CITY OF ALBUQUERQUE

RE: **Chick-fil-A**
2274 Wyoming Blvd NE
Grading and Drainage Plan
Engineers Stamp Date 12/15/14 (H20-D003C)

Based upon the information provided in your submittal received 2/2/2015, the above referenced Grading and Drainage Plan cannot be approved for Grading Permit or Building Permit until the following comments are addressed.

C-3.1

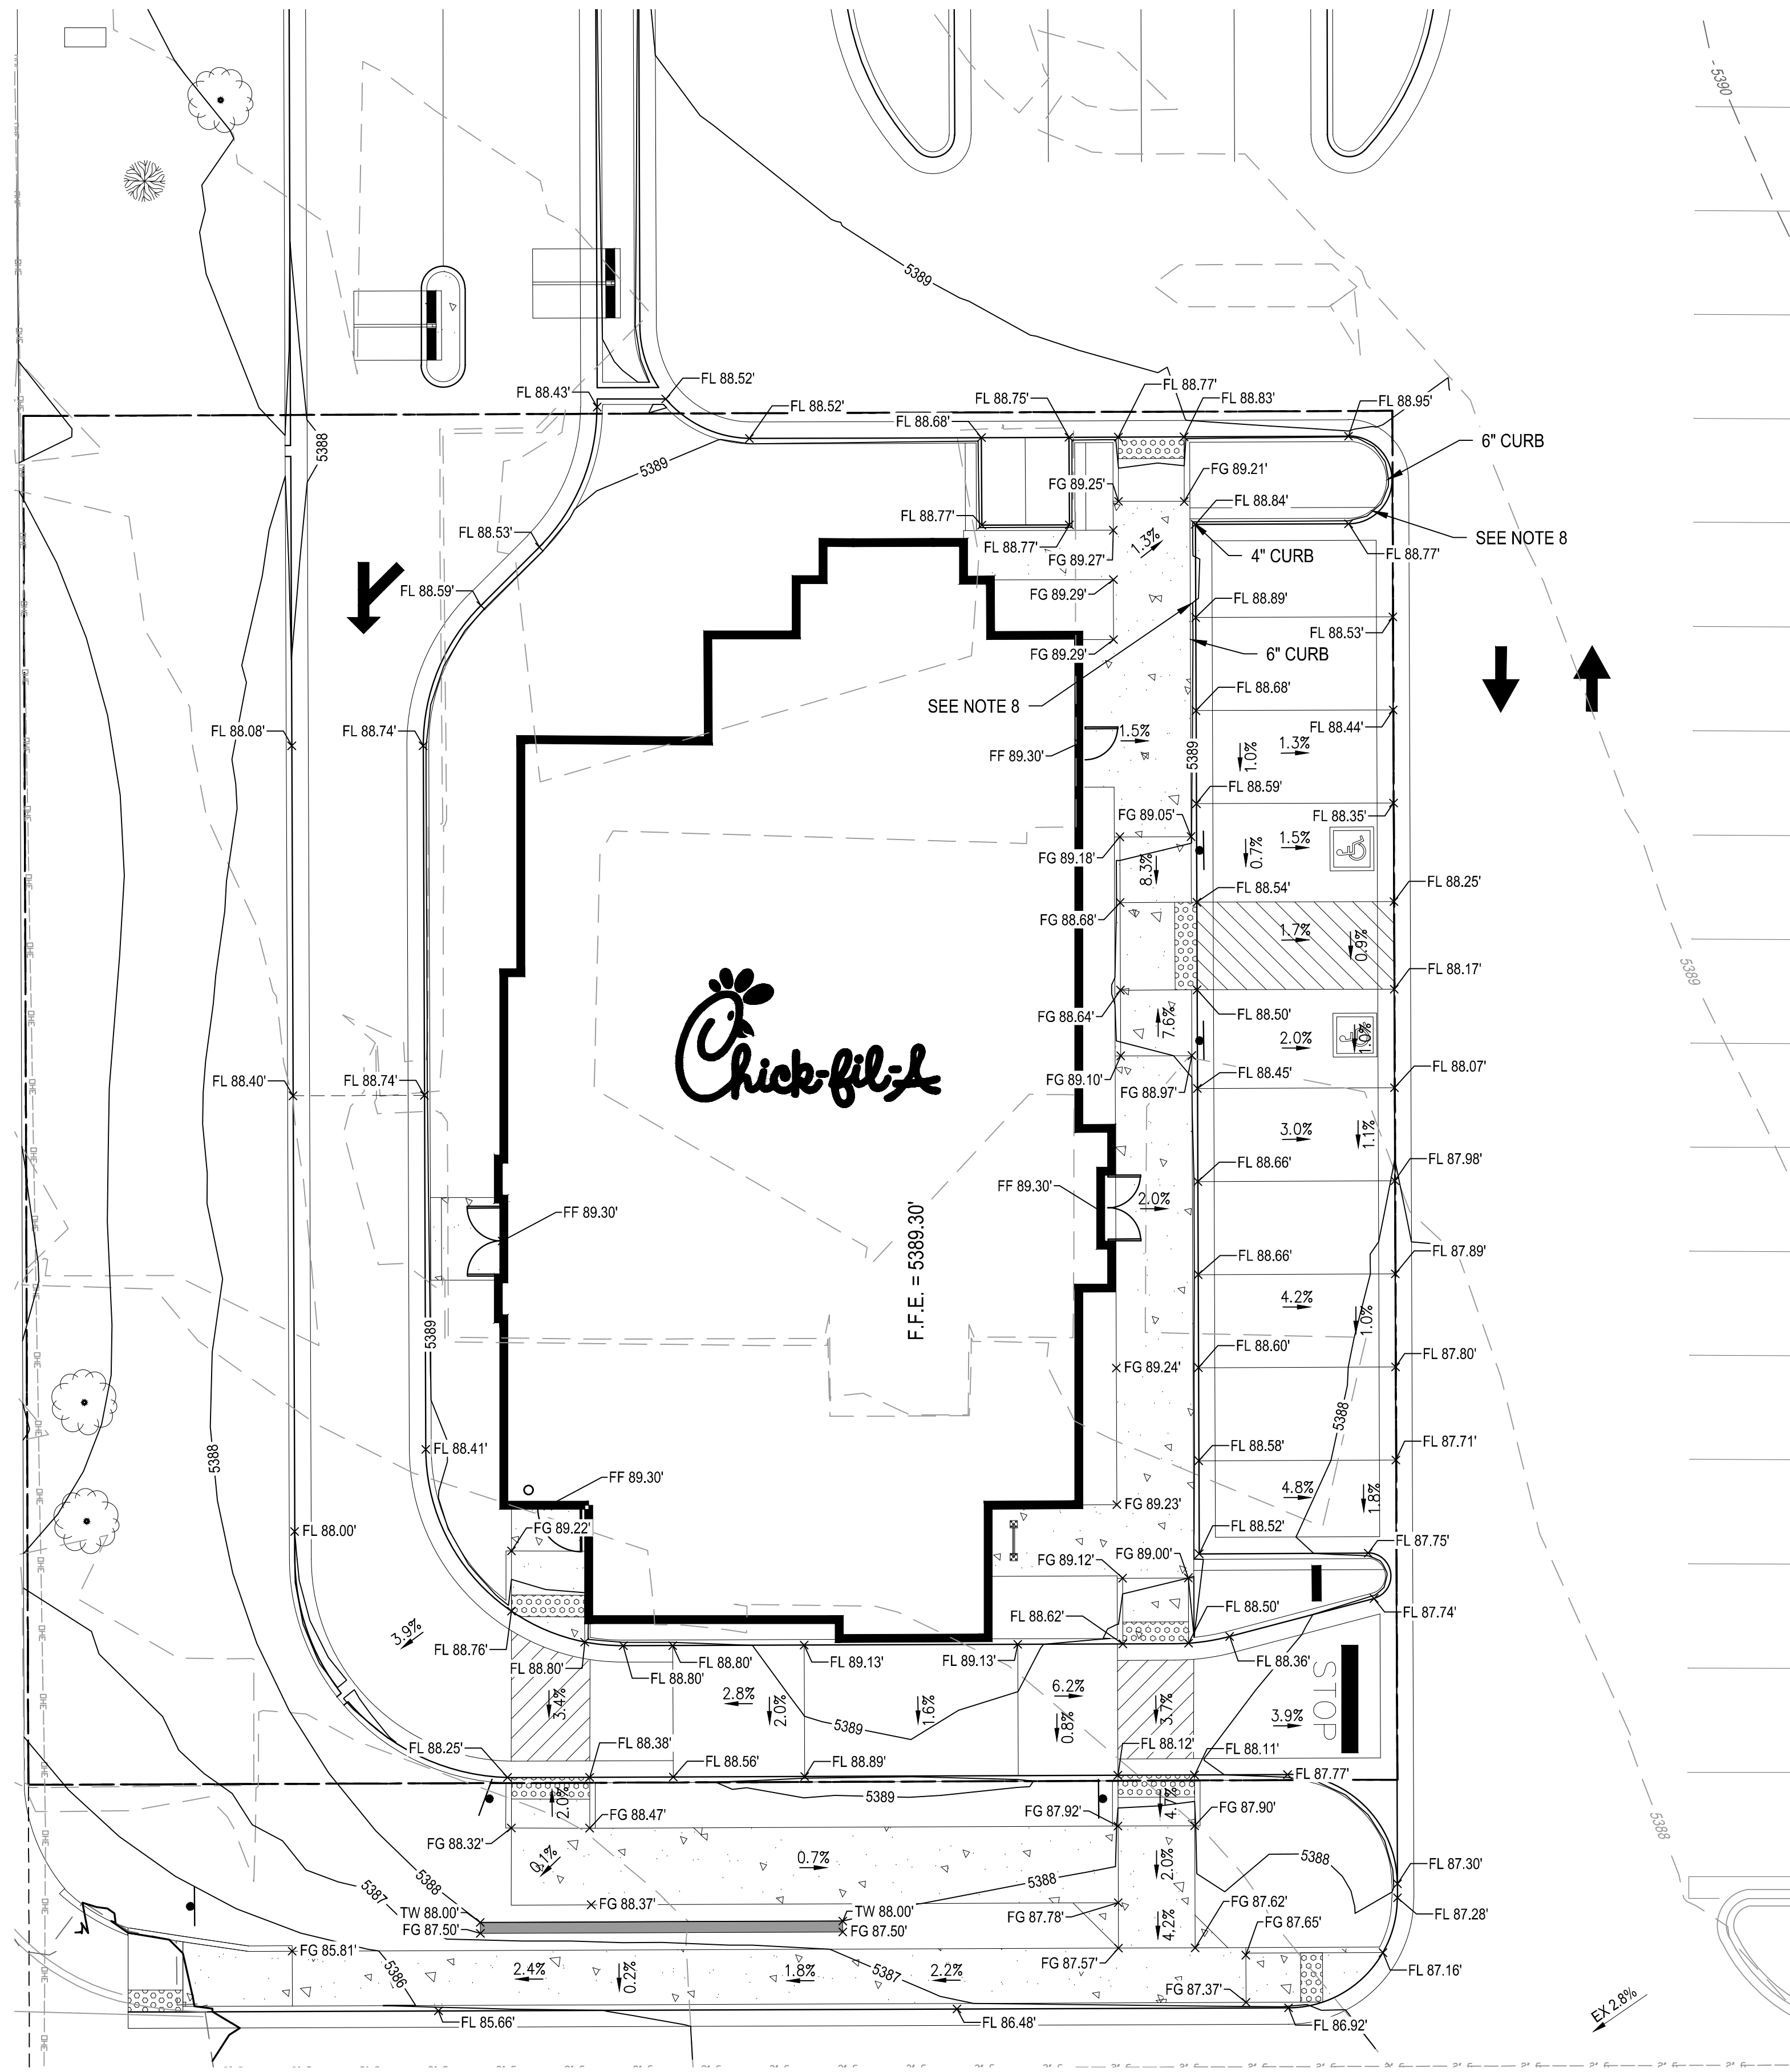
- Follow the Development Process Manual (DPM) Chapter 22 when submitting a plan for Grading Permit and Building Permit. This chapter can be found on our web site, www.cabq.gov/planning.
- Mention of the first flush per EPA standards is required. The amount required is .34" times the impervious area. We believe there is enough landscape area to accomplish this requirement.
- Provide the vicinity map. Also provide the FIRMette or mention the flood zone and map page.
- Provide the legal description on the G&D plan.
- Provide a basin map.
- Show the roof flows.
- Depress all landscape areas which are no closer than 10 feet from the building.
- Remove the "not for construction" note, all plans submitted for Building Permit and Grading Permit must be a plan used for building purposes.
- The dumpster area must contain a drain connected to the SAS, with a grease trap.
